<b>Project:</b>	Park Danforth
<b>Location:</b>	Portland, ME
<b>Becker Job No:</b>	3422

**OBSERVATION REPORT**

Cast in Place Concrete

**S1.1B**

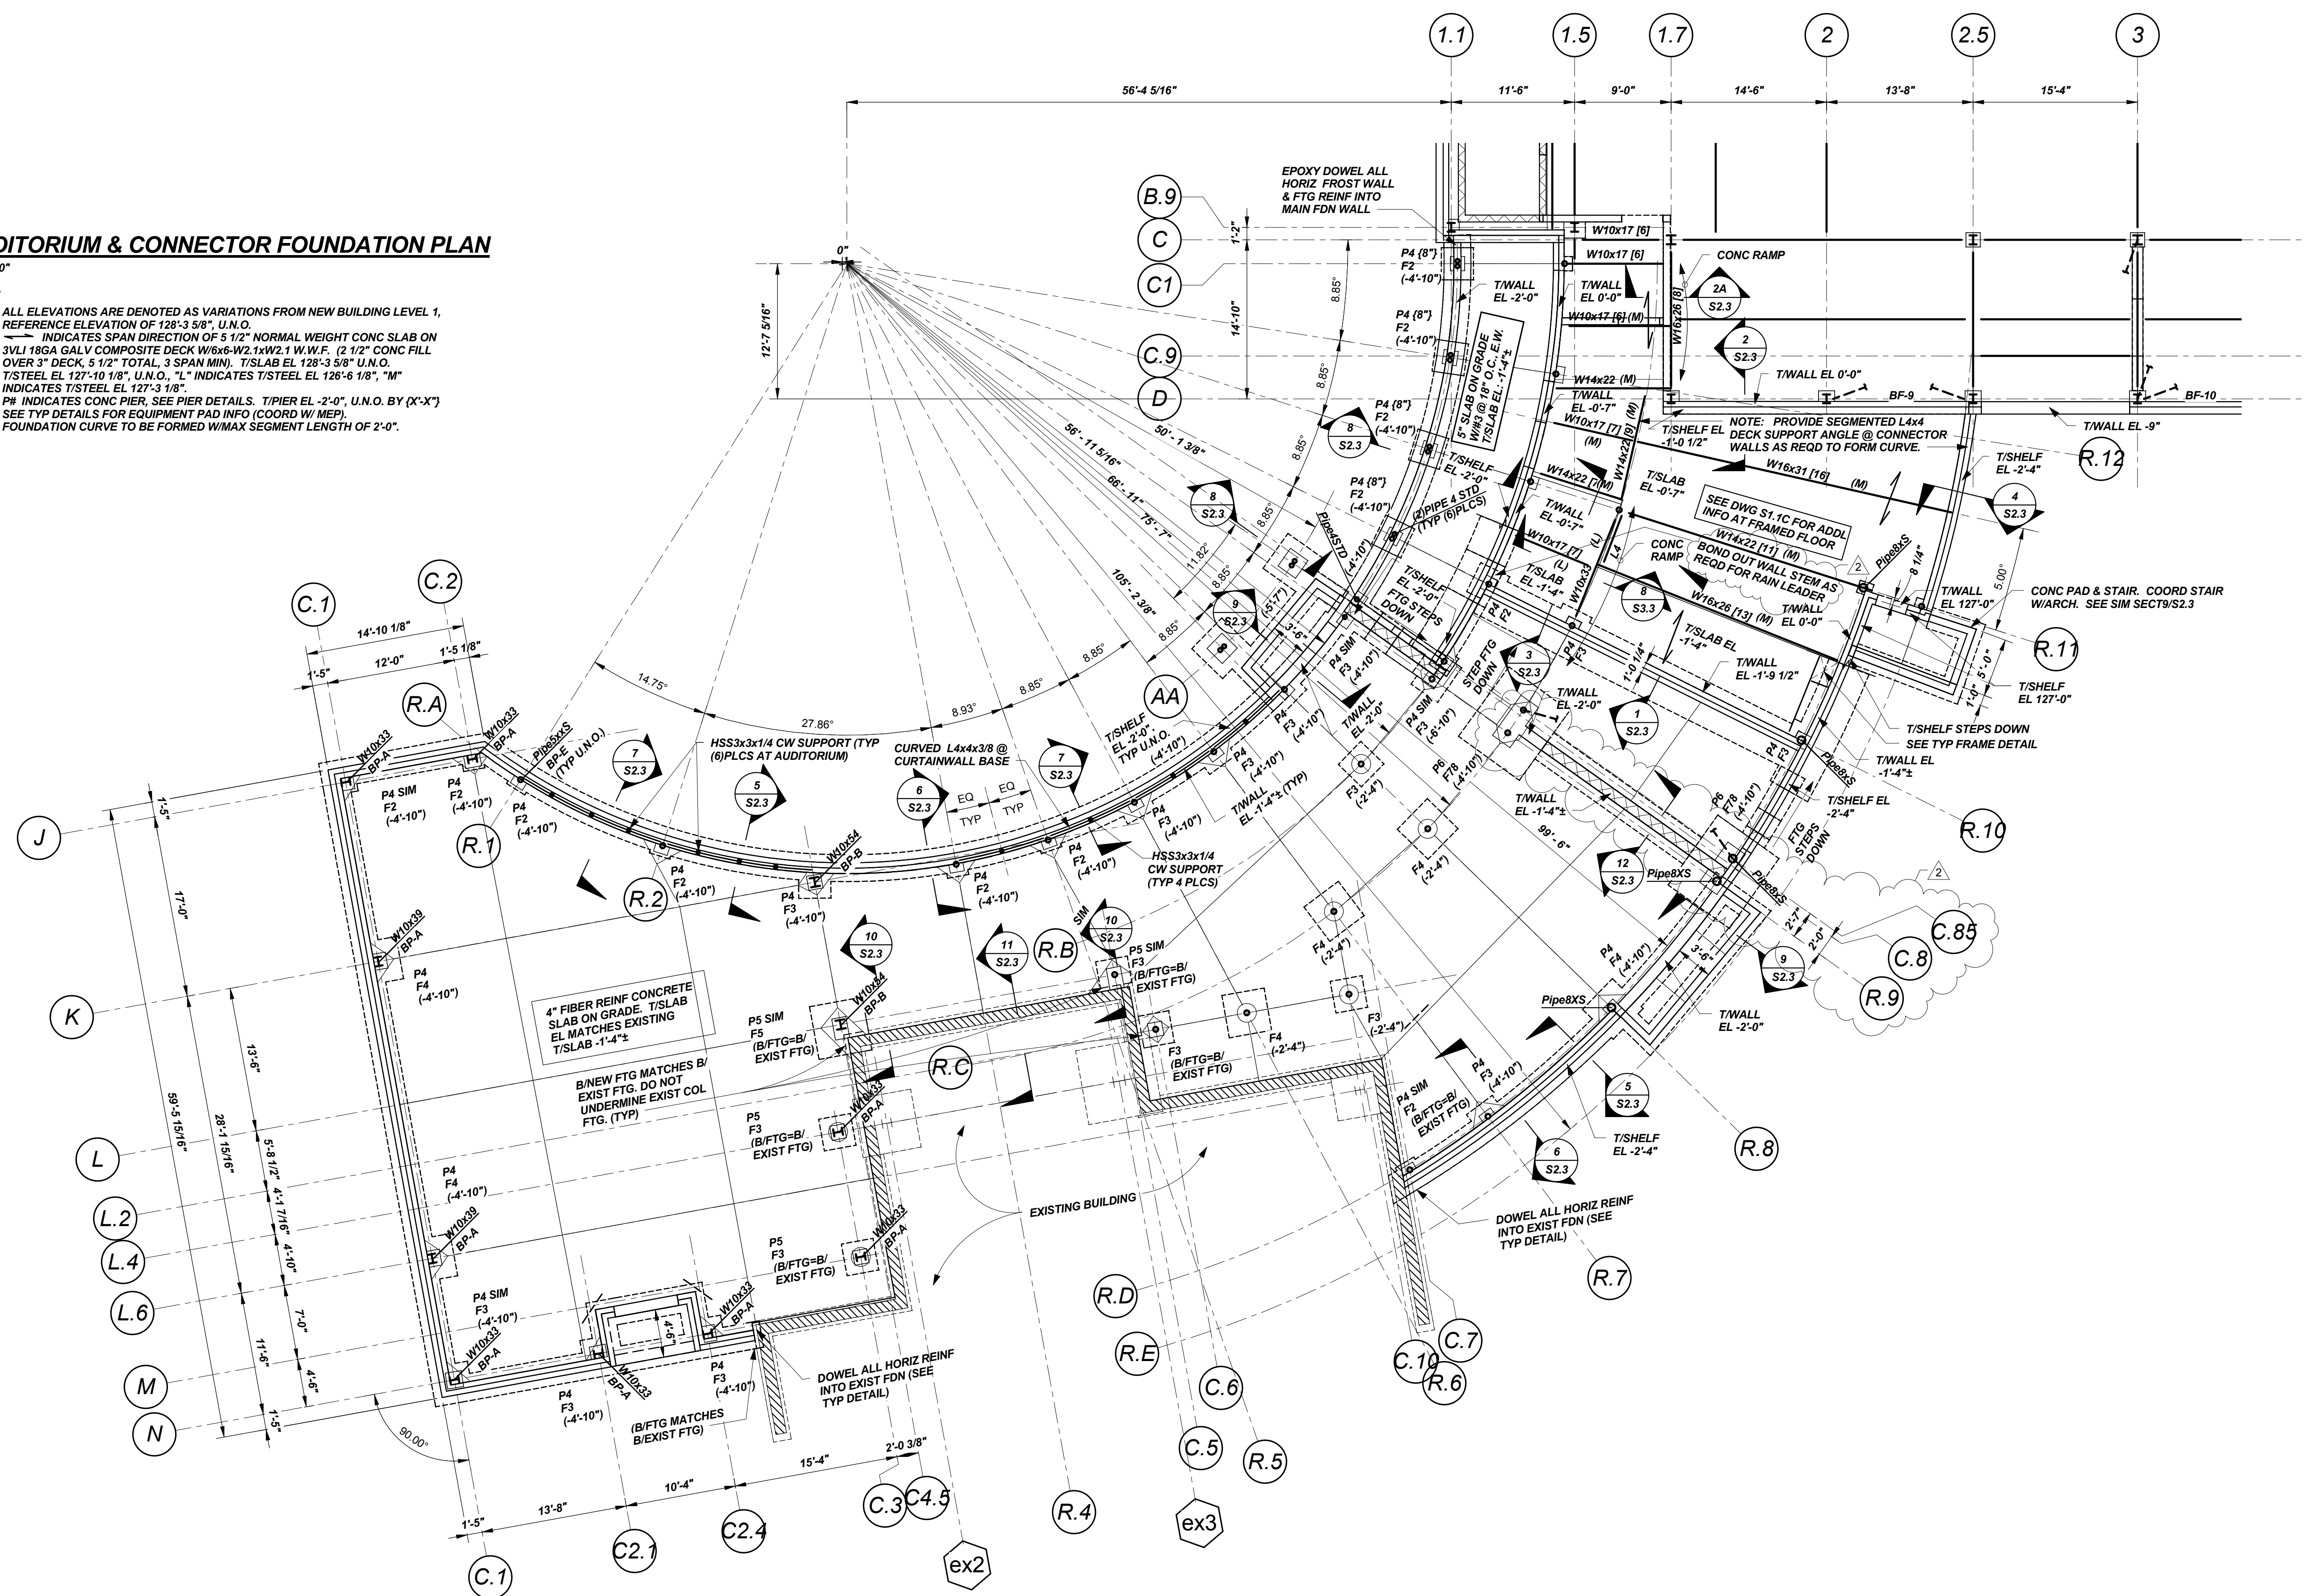
Chris from Giles asked for information regarding the note: "BOND OUT WALL STEM AS REQD FOR RAIN LEADER" on S1.1B. PC to coordinate the rain leader bond out requirements with the mechanical/architectural drawings.
